Application no: **3/2021/0280**

Address: **Newhurst Farm Anna Lane Bolton By Bowland BB7 4NZ**

Proposal: **Proposed conversion of barn to two dwellings and conversion of agricultural buildings to provide home office space and garages.**

PROJECT	Newhurst		
CLIENT	Holt		
TITLE	Plans - Sheet 1 of 2 PLANNING Ground / 1st		
DRAWING NO'	SCALE	STATUS	REVISION
ID-GA-01	1:100 @ A1	P

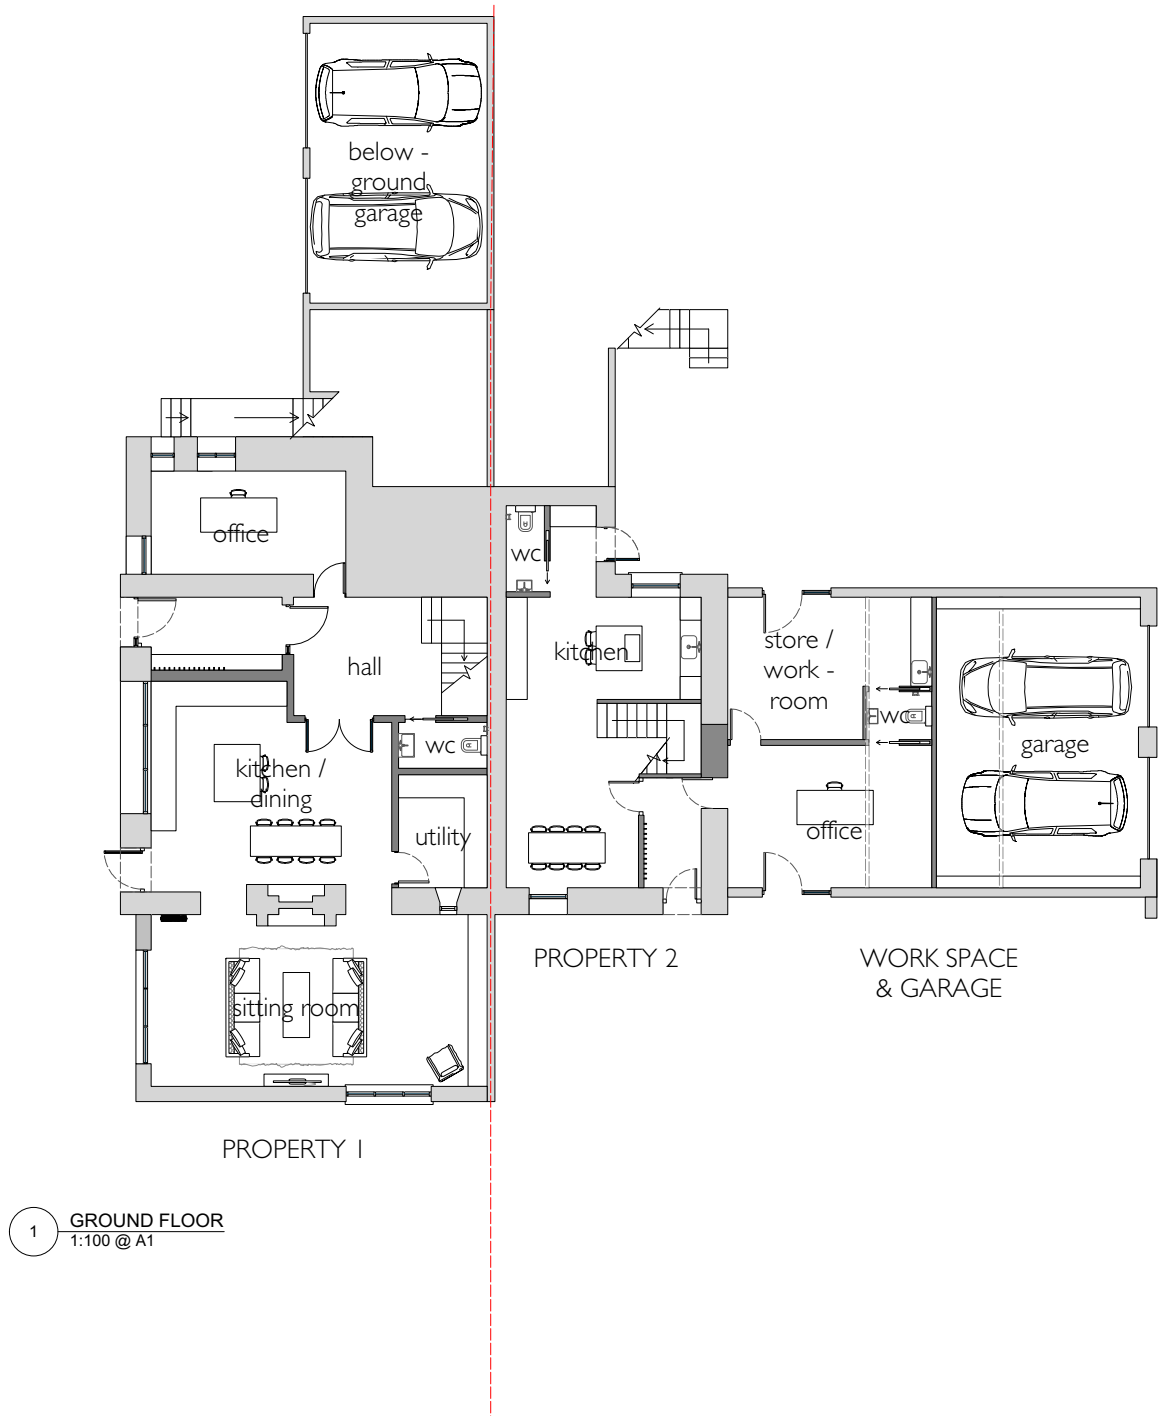
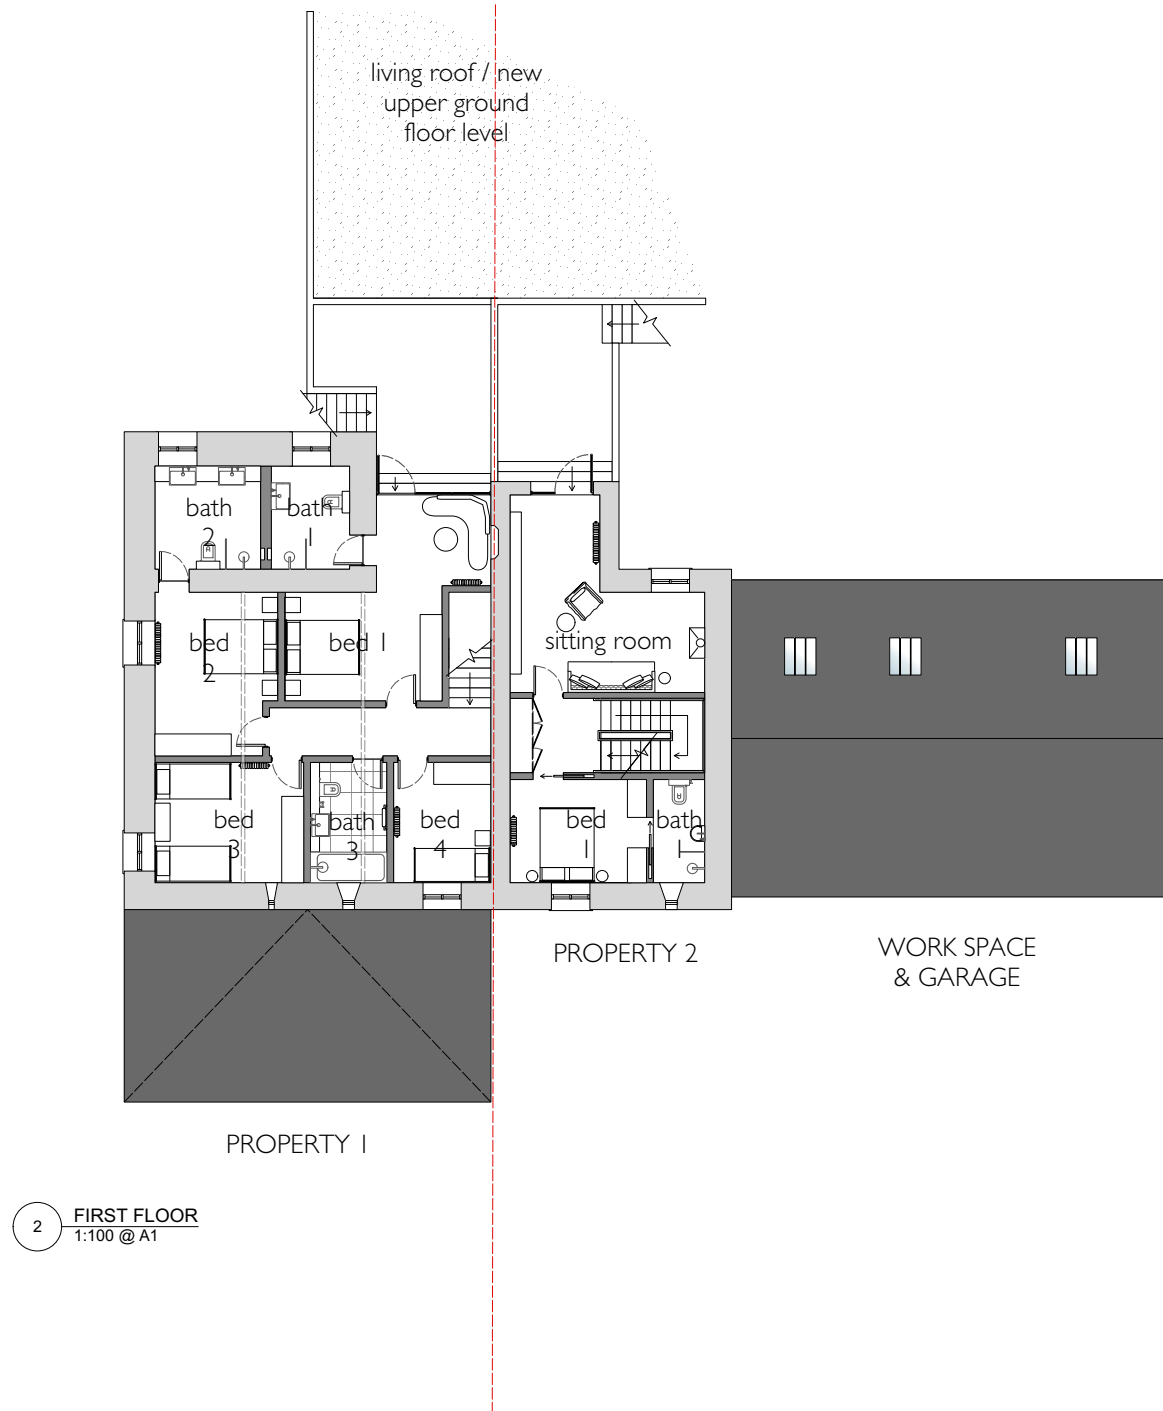
The LHA have reviewed the drawing titled "Plans- Sheet 1 of 2; Planning; Ground/1st" with the drawing number 1D-GA-01 and understands the site will provide 2 car parking spaces each for the 3 bed and 4 bed dwellings, respectively. These formal car parking spaces will be provided via the attached garages.

However, the LHA have reviewed the dimensions of both garages and understands they do not comply with Lancashire County Council guidance which requires a single garage to measure 3m x 6m and a double garage 6m x 6m. In comparison, Unit 1s garage measures 2.46m x 3.88m and Unit 2s 2.88m x 4.09m. Therefore, there is a significant shortfall in the dimensions of the proposed garages.

Despite this and the Applicant not providing any further supporting documents showing the parking layout at the site, the LHA understands the site has adequate space to provide at least 2 car parking spaces for the 3 bed and 3 car parking spaces for the 4 bed dwellings.
